Public Authorities

Comment	Response	Where addressed
NRAR		
Thank you for contacting the Natural Resources Access Regulator. This is a pre-approval matter that needs to be sent to landuse.enquiries@dpi.nsw.gov.au to collate a combined response from both NRAR and DPIE Water.	We note the NRAR comments. These appear to be of a procedural nature and do not request specific information or raise specific issues. No response is required.	N/A
DPI Fisheries		
Hi James, As the subject is not within Key Fish Habitat, DPI Fisheries has no comments on the proposal.	We note the DPI Fisheries comments. No response is required.	N/A
Heritage NSW – Heritage Council of NSW		
In accordance with our previous correspondence dated 3 December 2019, the subject site is not listed on the State Heritage Register (SHR), nor is it in the immediate vicinity of any SHR items. Further, the site does not contain any known historical archaeological relics. Therefore, no further heritage comments are required. The Department does not need to refer subsequent stages of this proposal to the Heritage Council of NSW.	We note the Heritage NSW comments. No response is required.	N/A

Appendix A13 – Extraction Phasing Plan

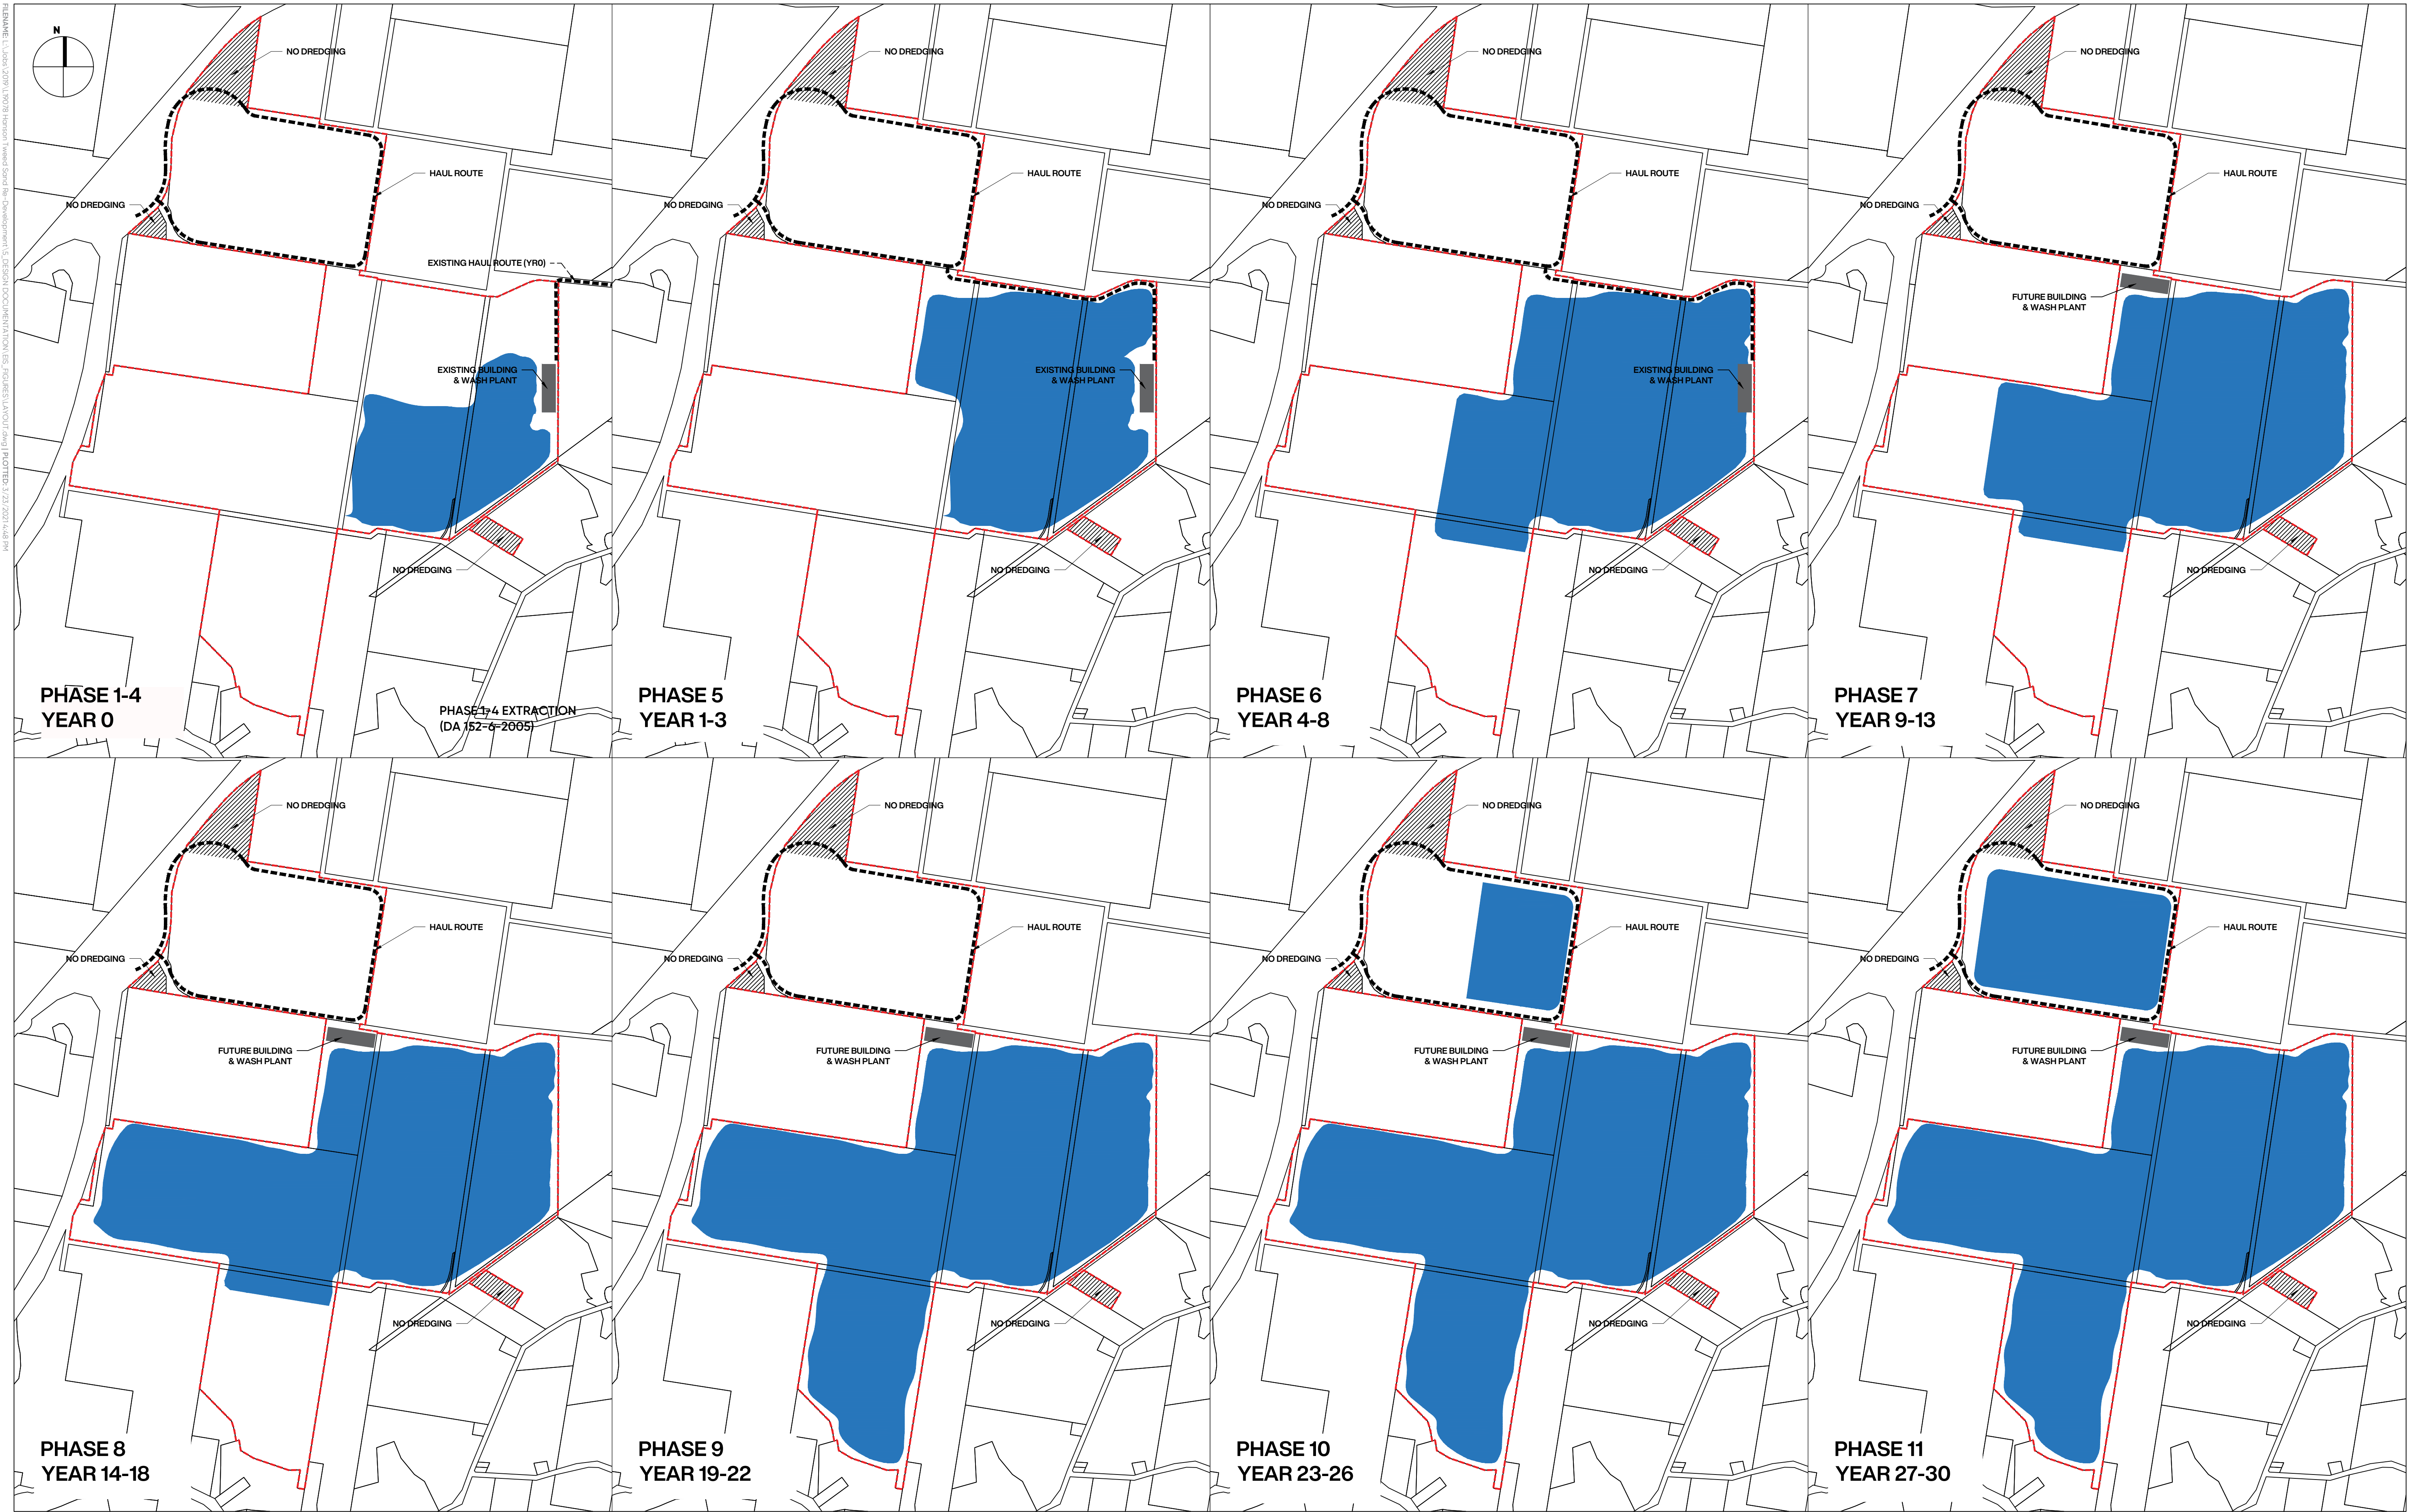
<p>Geotechnical Report</p> <p>6. The EIS proposes the extraction of material to a depth of 20m below ground level and within 10m of the project site boundaries. Appendix A13 identifies that the phases 8 and 13 of extraction will be in the vicinity of the Pacific Motorway interchange. TfNSW has concerns regarding the proposed depth and proximity of extraction to the Motorway and the resulting implications for future planning and State infrastructure.</p> <p>TfNSW is seeking internal geotechnical advice and will further advise the Consent Authority of an appropriate setback from the Freeway corridor to ensure the final arrangement is safe, secure and stable. Our interim request is that the Consent Authority impose a hard setback of 40m from the Freeway corridor boundary.</p>	<p>An increase of the buffer width to Pacific Highway Road Reserve (excluding that part adjacent the offramp) has been incorporated. The buffer to the Pacific Highway Road Reserve is now 50m. The buffer to the part of the road reserve that contains the off ramp remains at 10m.</p>	<p>Attachment 9 – Revised Appendix A14 – Site Layout Plans</p>
